**Proposal:** Discharge of condition 6 (segregated pedestrian and cycle path) of 21/03177/F

- 2.1. This submission seeks to discharge condition 6 of 21/03177/F, which relates to the details of the segregated pedestrian/cycle path.

NOTES

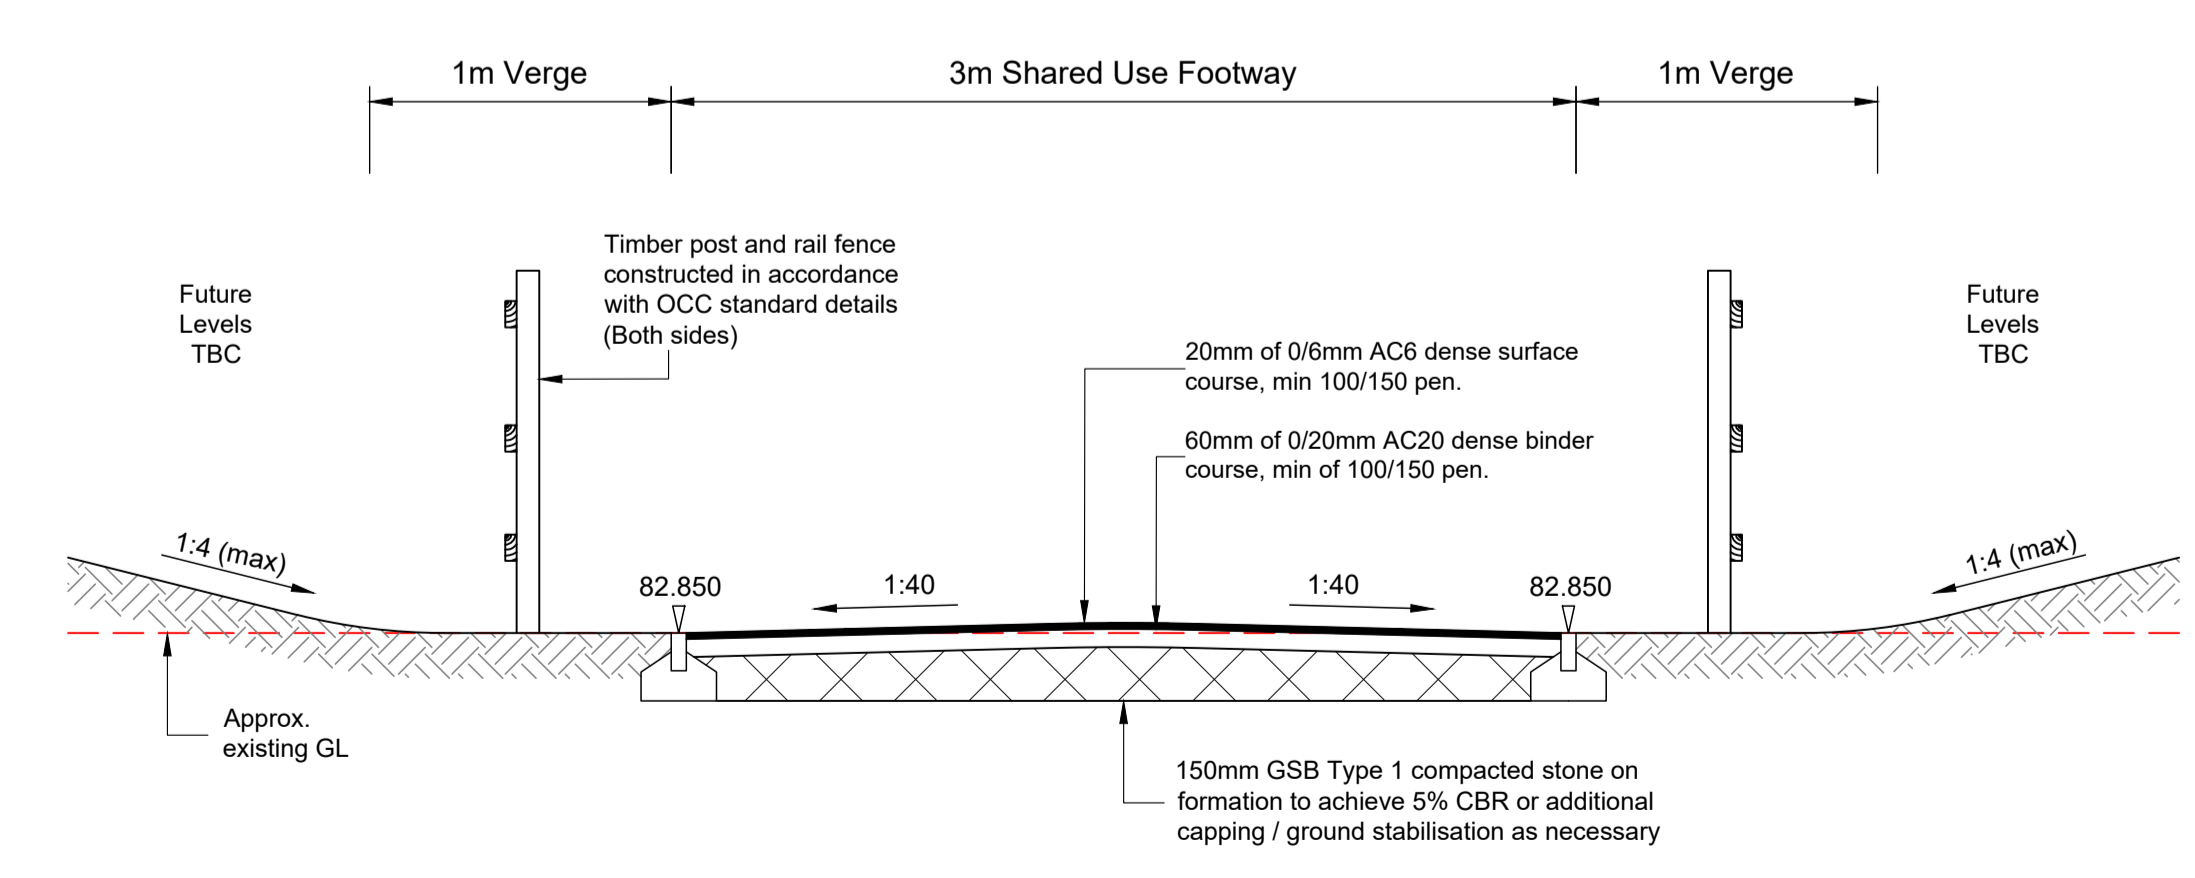
- 6.2. The LHA have reviewed the information and are content with the details. The path will link to a new toucan crossing on Howes Lane, which is the subject of a S278 application to OCC, whereby the detail will be agreed. It's assumed that this path will be part of a S38 submission, whereby the technical detail will be agreed. However, it is acceptable in principle. The path is proposed as a 3m wide shared use path, which is in line with the planning permission and acceptable here as in the longer term the path will have a relatively low level of usage, the main route being provided

via the paths alongside the new strategic link road. Drawing 0002-1001 P0 Site Roadway Lighting, shows that the path will be lit.
